**WELWYN HATFIELD BOROUGH COUNCIL
ASSISTANT DIRECTOR (PLANNING)**

DELEGATED APPLICATION

Application No: 6/2023/1422/HOUSE
Location: 52A Plough Hill Cuffley Potters Bar EN6 4DS
Proposal: Installation of automated and manual swinging gates
Officer: Ms Kirsty Shirley

Drawing No. J35365-PC-02

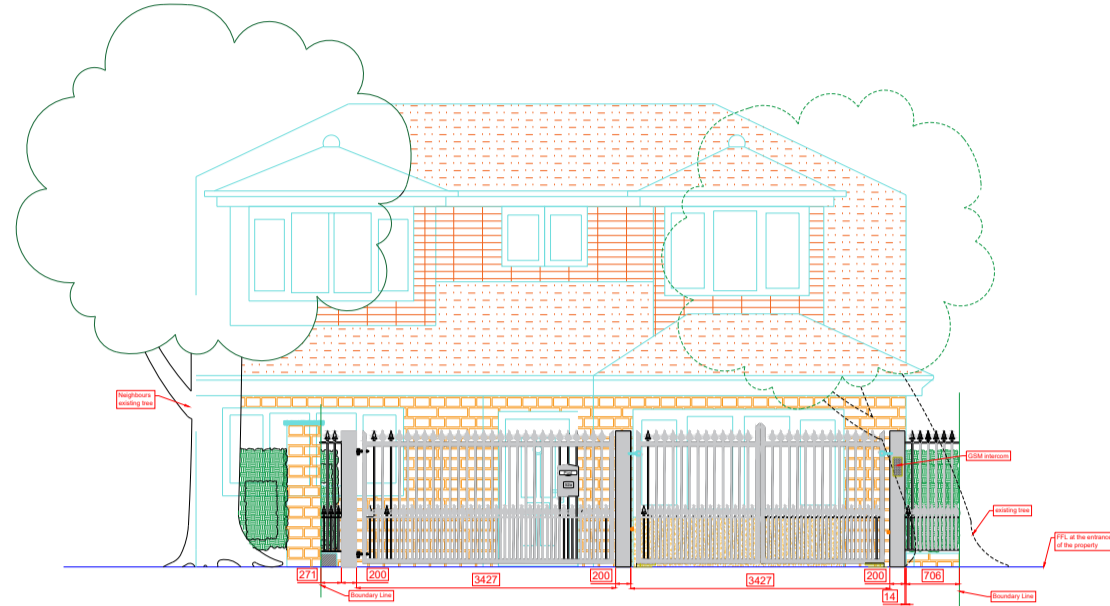
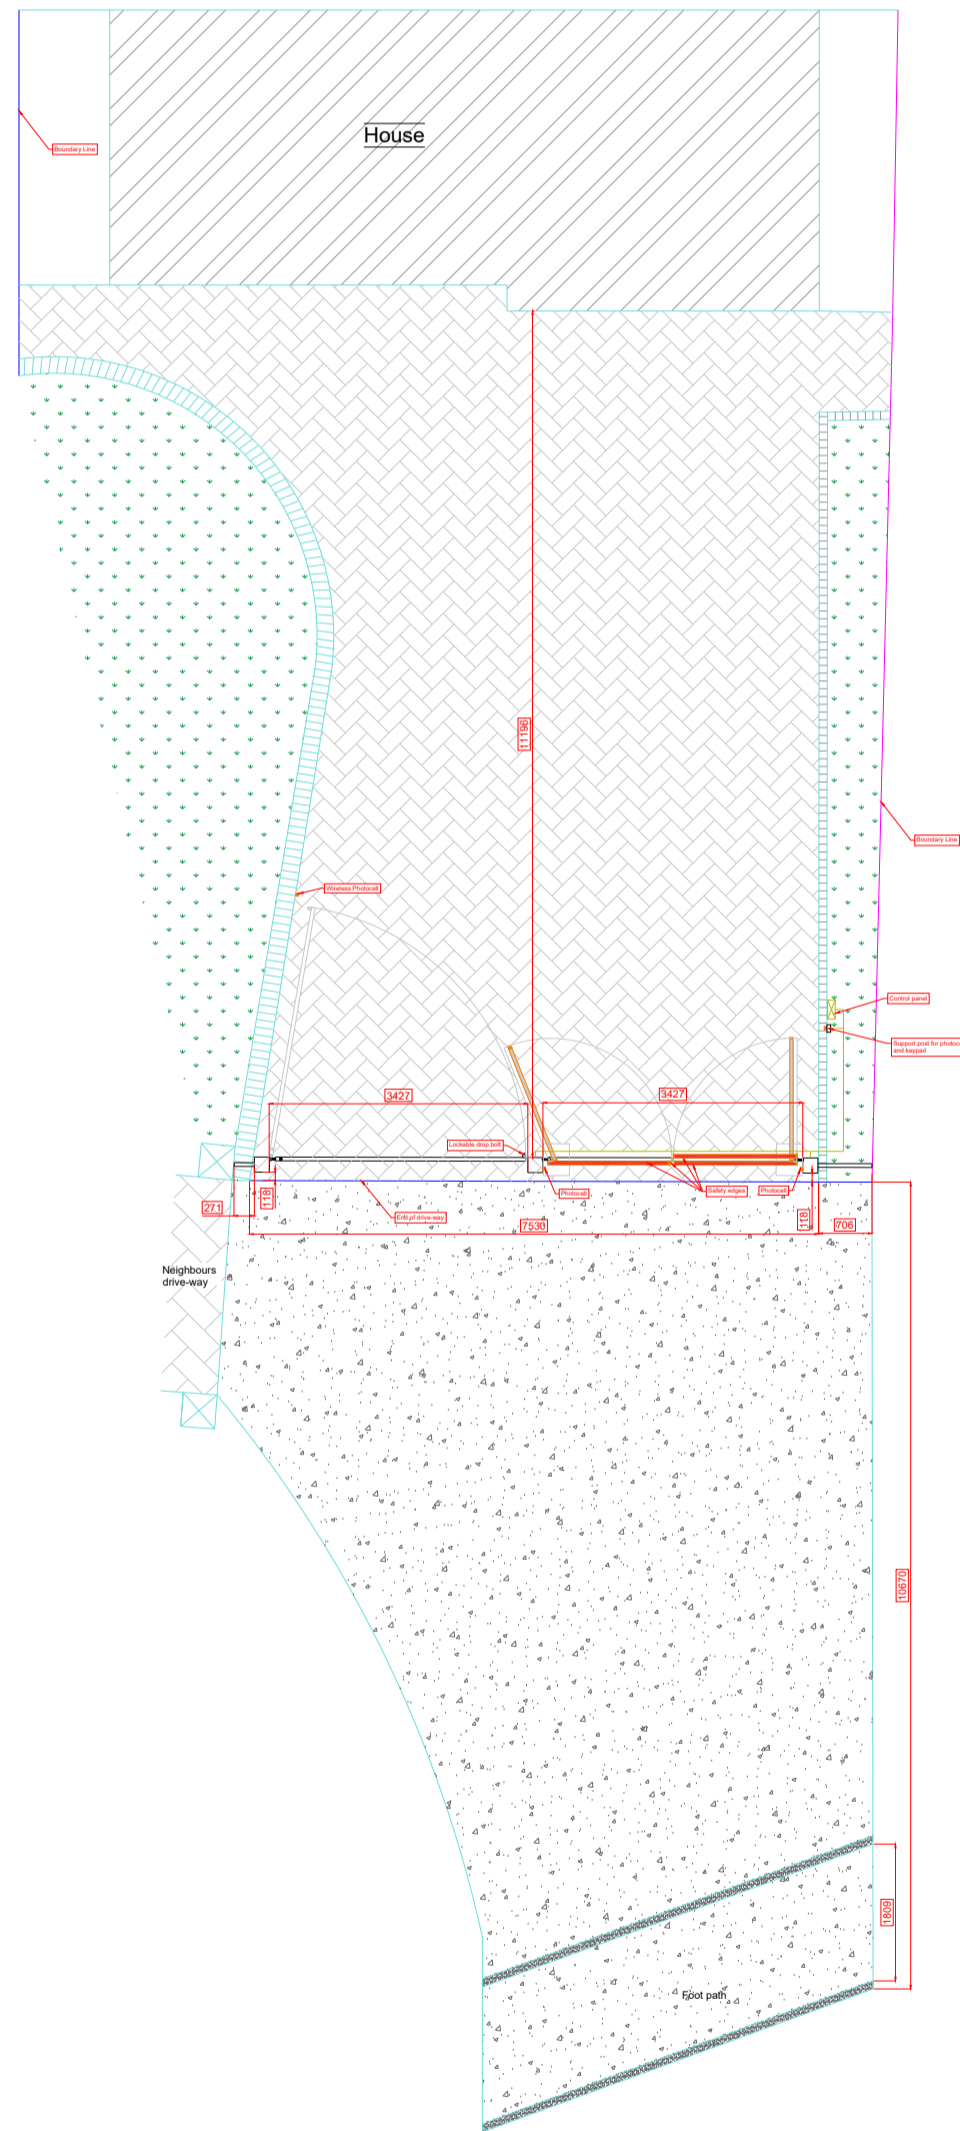
Comment (if applicable):	
Would the development reflect the character of the area?	
<input checked="" type="checkbox"/> Yes <input type="checkbox"/> No	
<p>Comment (if applicable): The proposal is for the installation of one automated sliding gate and one manual swinging gate. The gates would be positioned in alignment with one another and would be substantially setback from the highway. The gates would feature round vertical bars with decorative Fleur-de-lis finials. The bars would be at two different heights, with bars approximately 0.7m in height positioned in between bars that are approximately 1.7m in height. The gates would be supported by three square support posts which would be approximately 1.8m. The gates would be constructed of steel with a black satin finish and would be similar in height to the boundary treatments at No. 52 and No. 50.</p> <p>The boundaries of nearby properties tend to be characterised by open, verdant frontages. Where enclosures are featured, these feature material and finishes typically reflect the material and finishes of the host dwelling of the site.</p> <p>The proposed boundary treatment would exclusively use metal railings. Black metal railings are noted as part of boundary treatments on adjoining neighbours No. 50 and No. 52 as well as within the immediate area of the site. Boundary treatments using black metal railings exclusively are noted particularly on East Ridgeway.</p> <p>While the material and finish of the metal railings would not reflect the materials or finishes of the application dwelling, the scale and design of the metal railings would not harmfully detract from the appearance of the dwelling. The style and height of the metal railings would relate to the character and context of the area. The colour of the metal railings can be secured by condition to ensure the development remains in keeping with the character and appearance of the area.</p>

1. The development must not be carried out other than in accordance with the details of external materials specified on the submitted application form. Details of any alternative materials to be used in the construction of the external surfaces shall be submitted to and approved in writing by the Local Planning Authority prior to above ground development. The development shall be implemented using the approved materials and subsequently, the approved materials shall not be changed.
